Date: 14-Nov-2019
Our Ref: 2019/93214

**Discharge of conditions 4. (retaining wall details) & 7. (site management plan) on
previous permission no. 2013/93917 for erection of a detached dwelling and
formation of a new access**

**Hazeldene House, Stoney Bank Lane, Thongsbridge, Holmfirth, HD9 7LZ
Application Number: 2019/93214**

PROJECT HAZELDENE STONEY BANK LANE NEW MILL, HOLMFIRTH				
TITLE ACCESS ROAD RETAINING WALL PLAN, SECTIONS AND DETAIL				
PROJECT No. 2019/263	DRAWING No. 01	AMENDMENT -	DATE DRAWN 16 AUG 19	DRAWN BY IG
Amendment Note			Date Revised

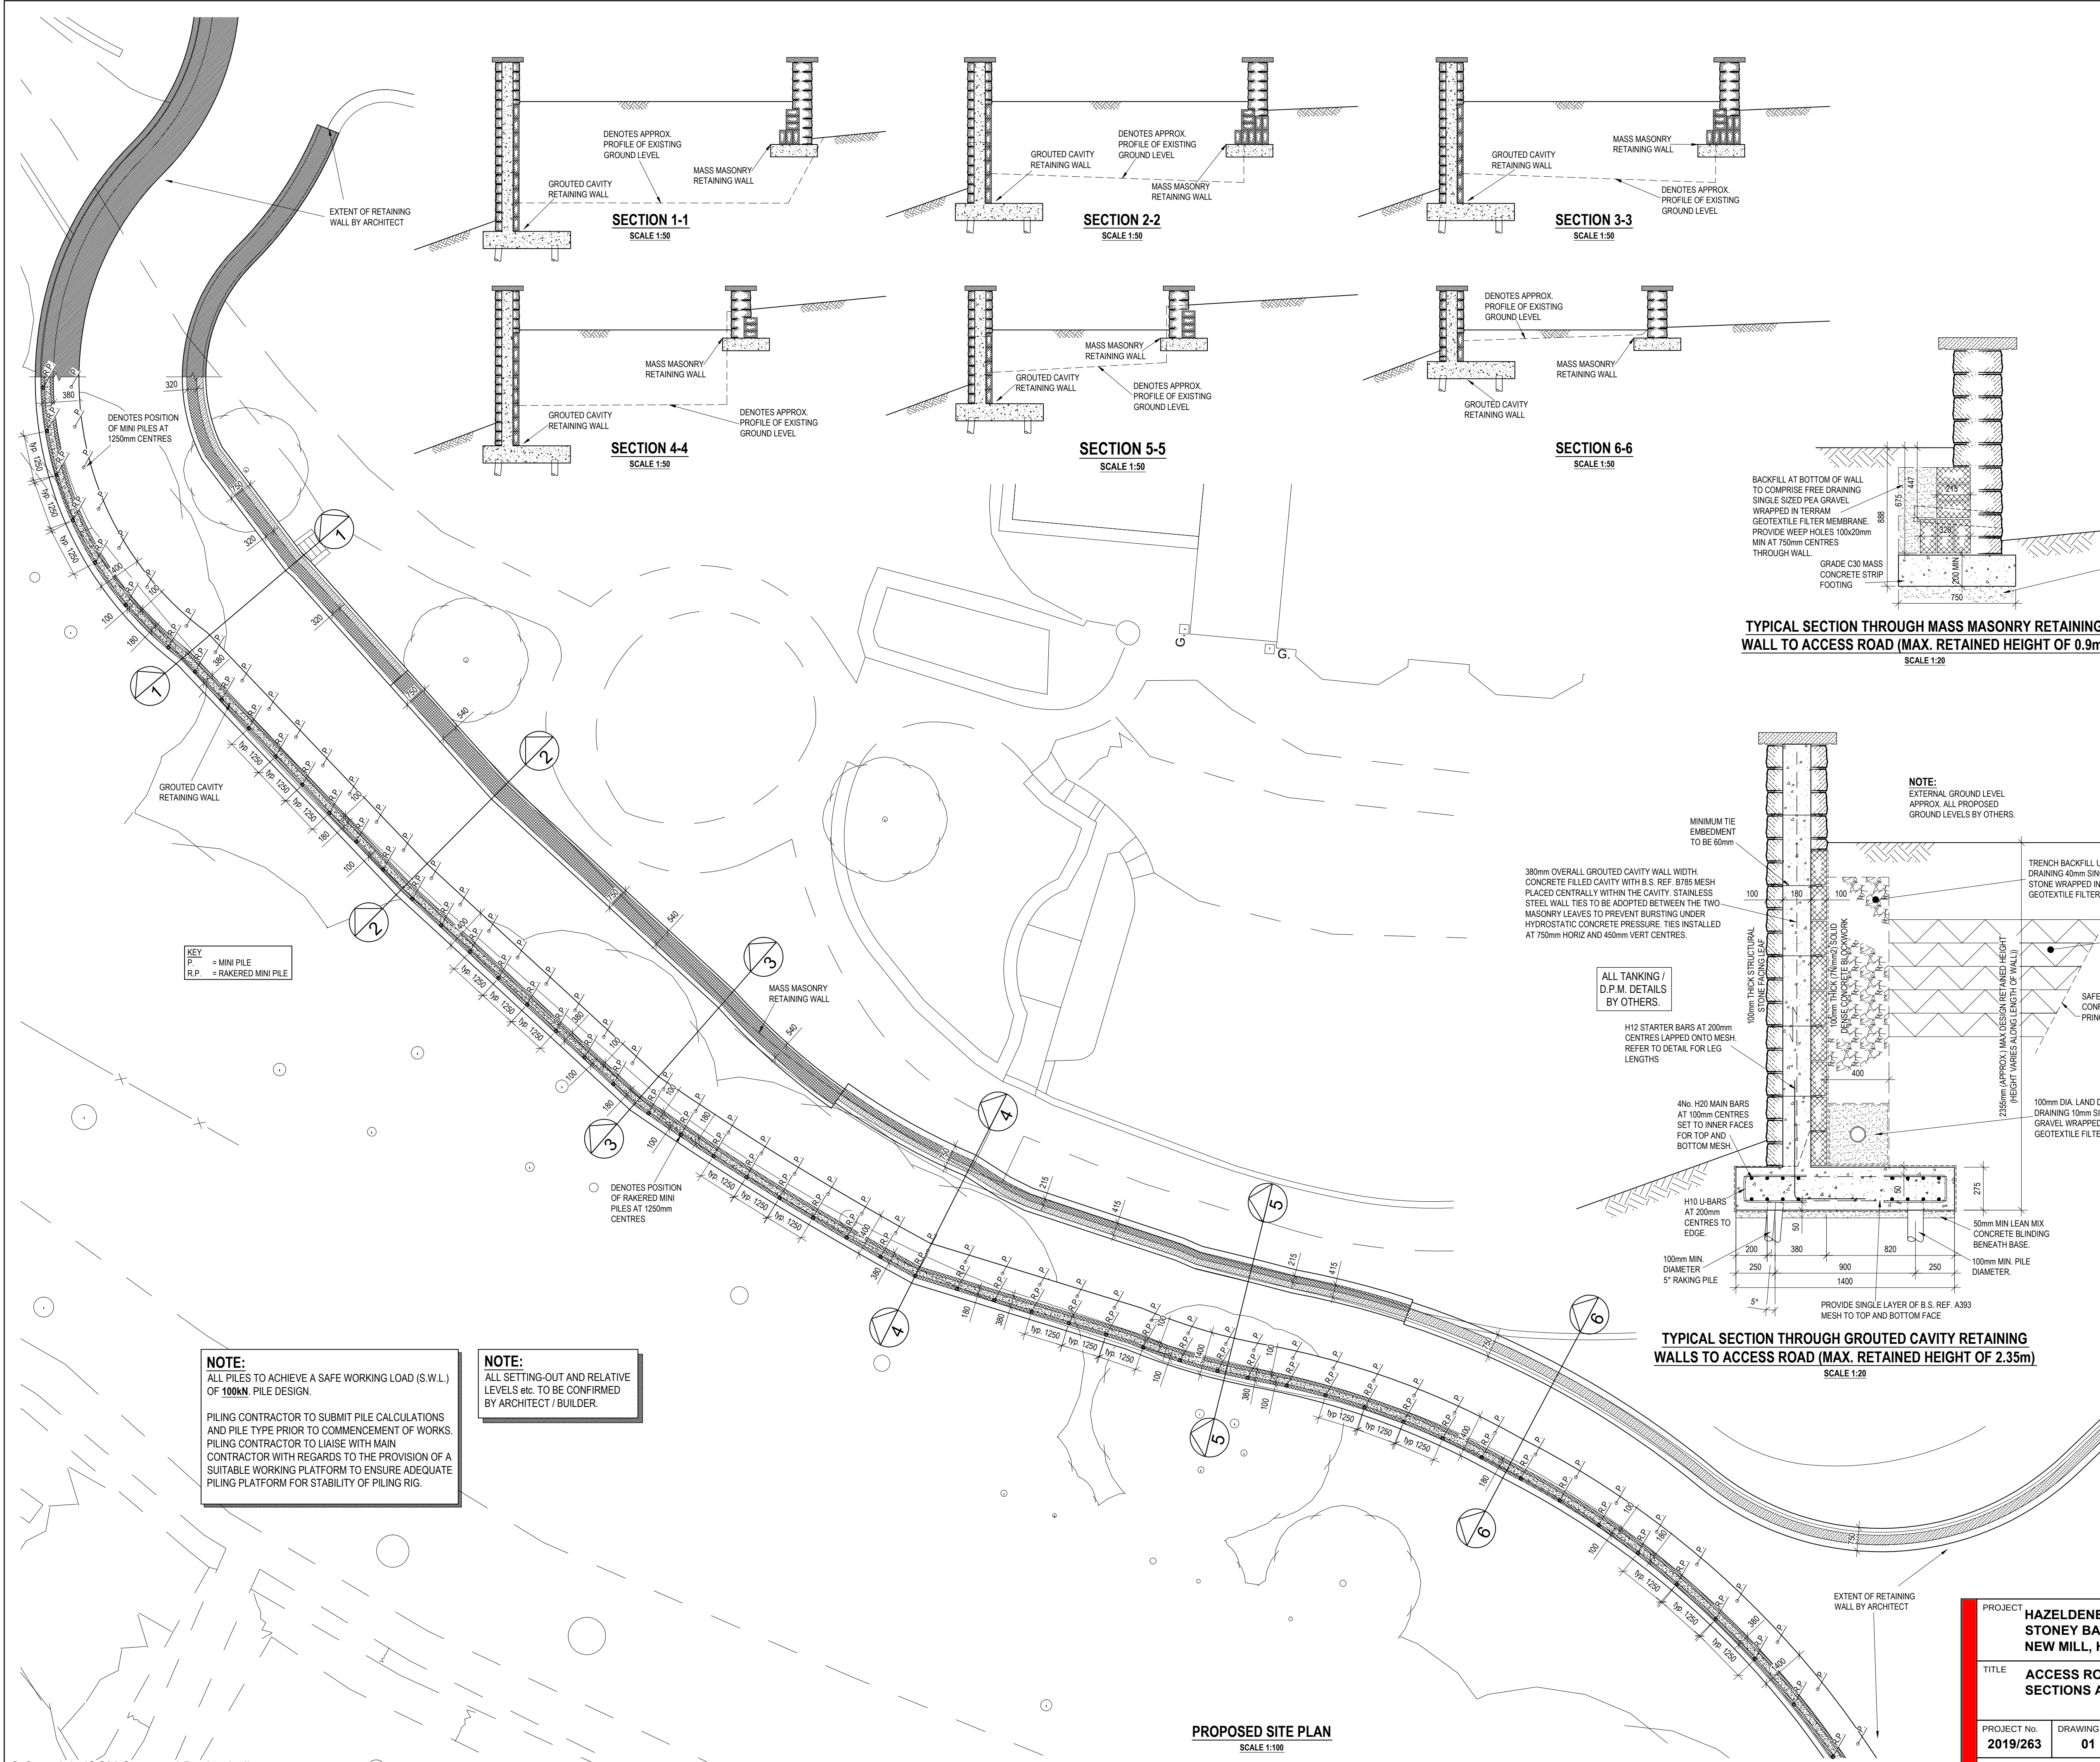
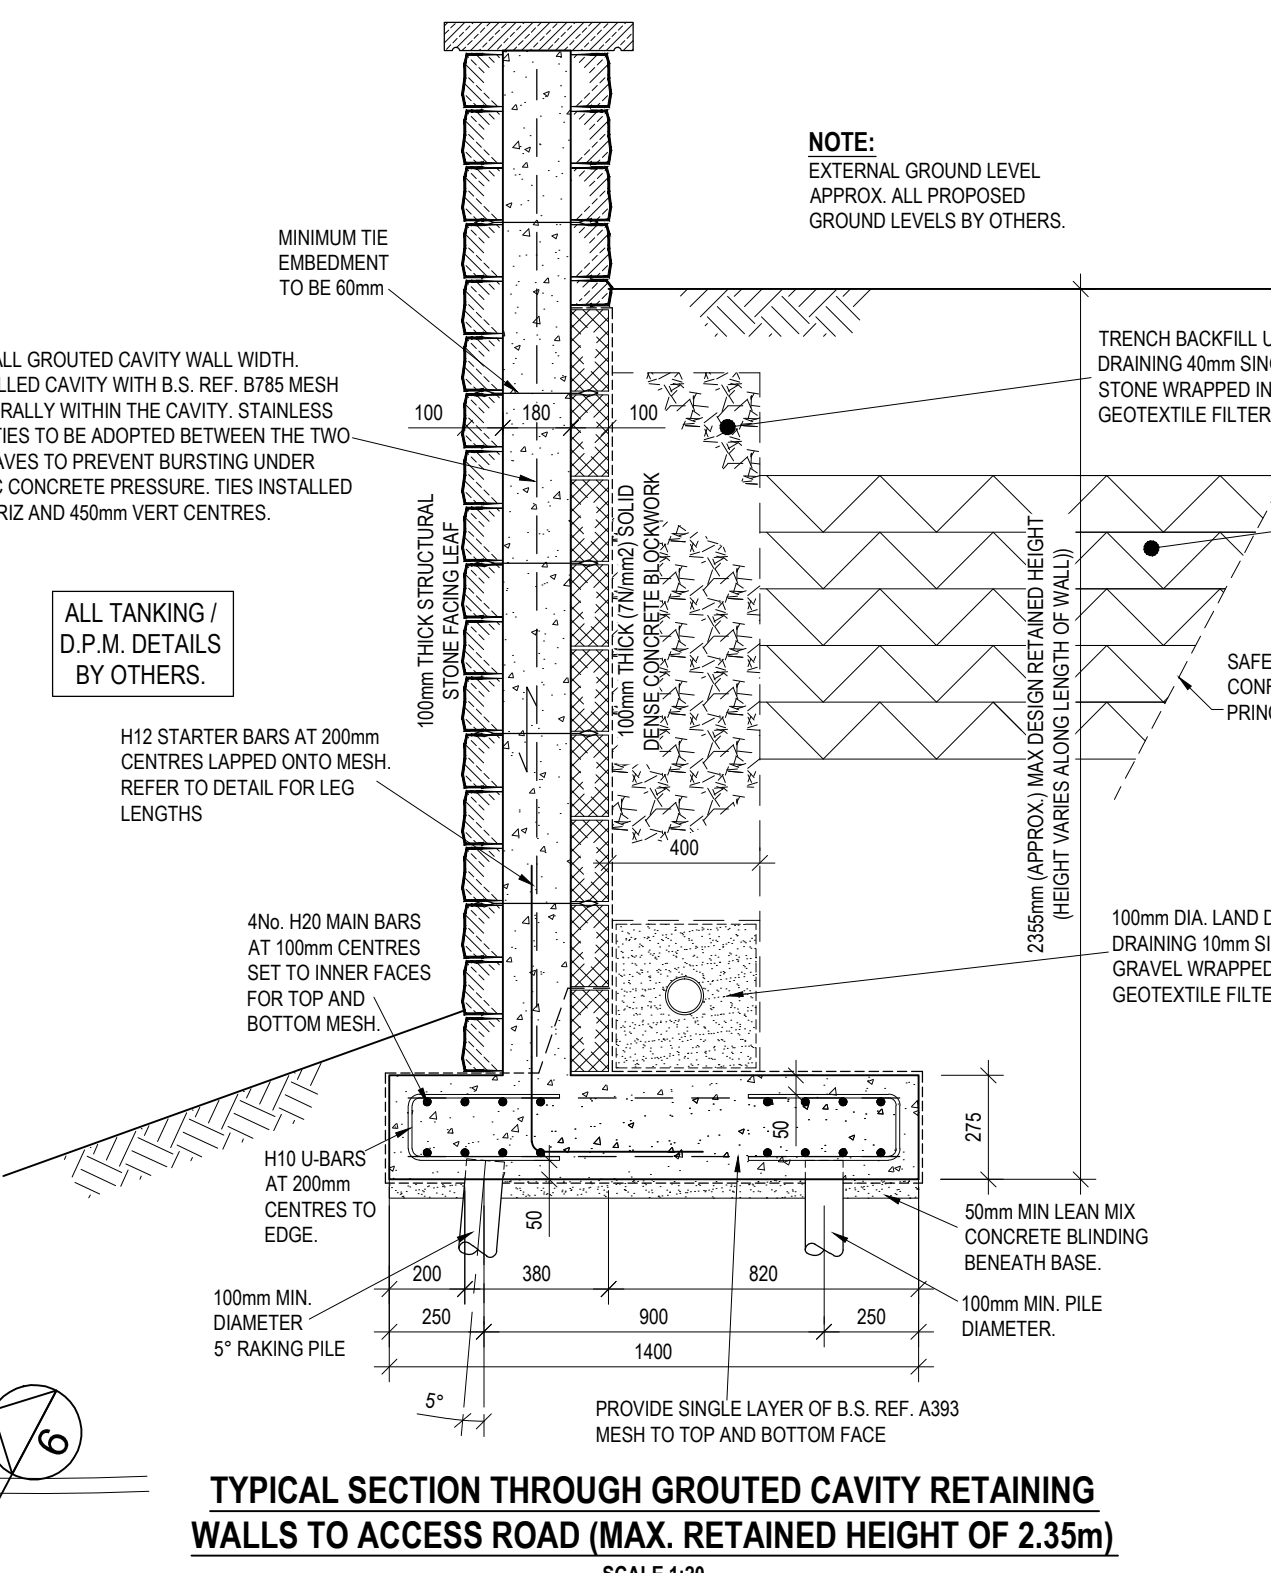
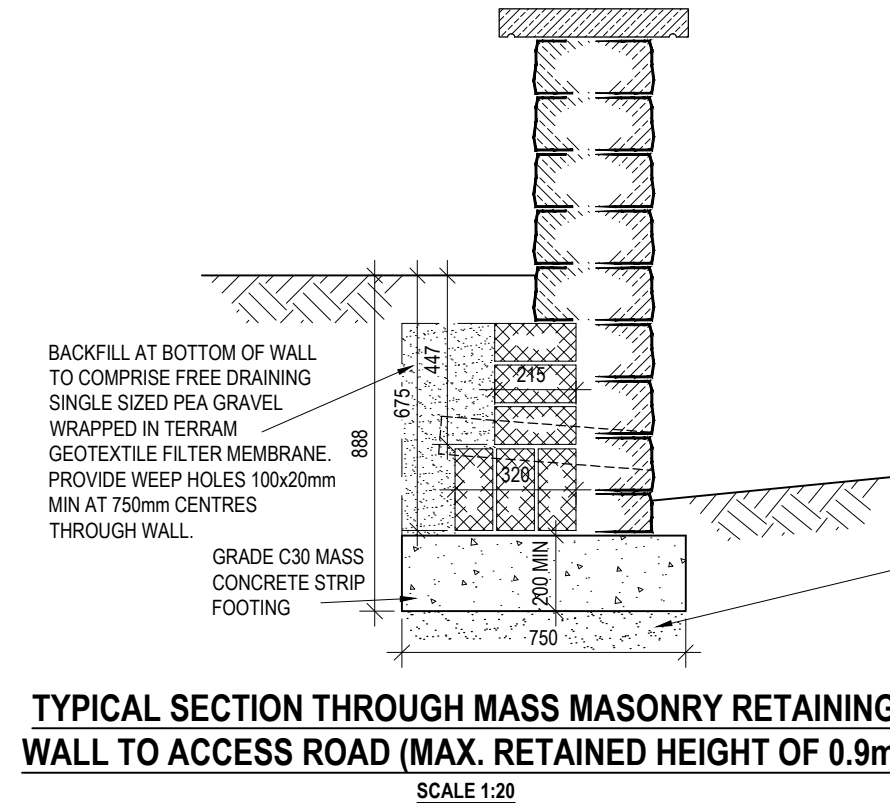
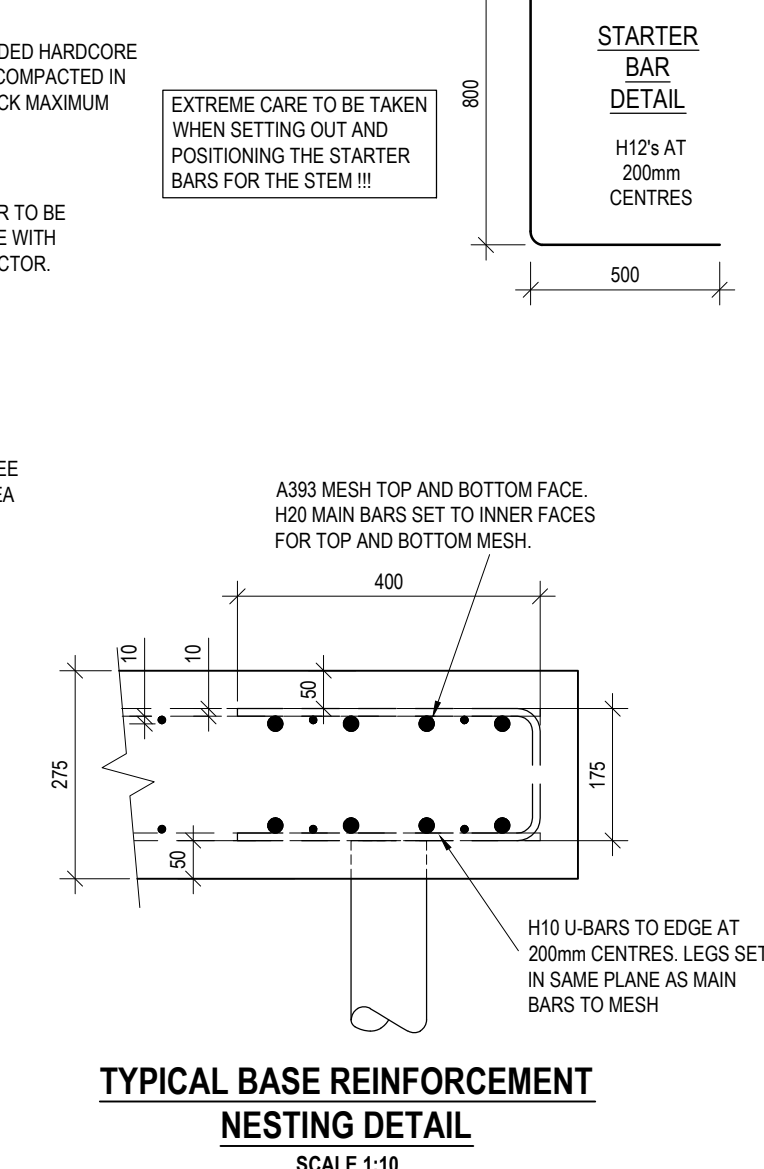
With regards to Condition 4, you have submitted drawing (ref 2019/263/01) dated 16 Aug 19 detailing the access retaining walls. The details have been assessed by KC Highways DM. The retaining wall element is located far enough away from Stoney Bank Lane to not be considered a highway retaining wall, as such is considered acceptable. Condition no. 4 will be satisfied subject to the development being carried out in accordance with these details.
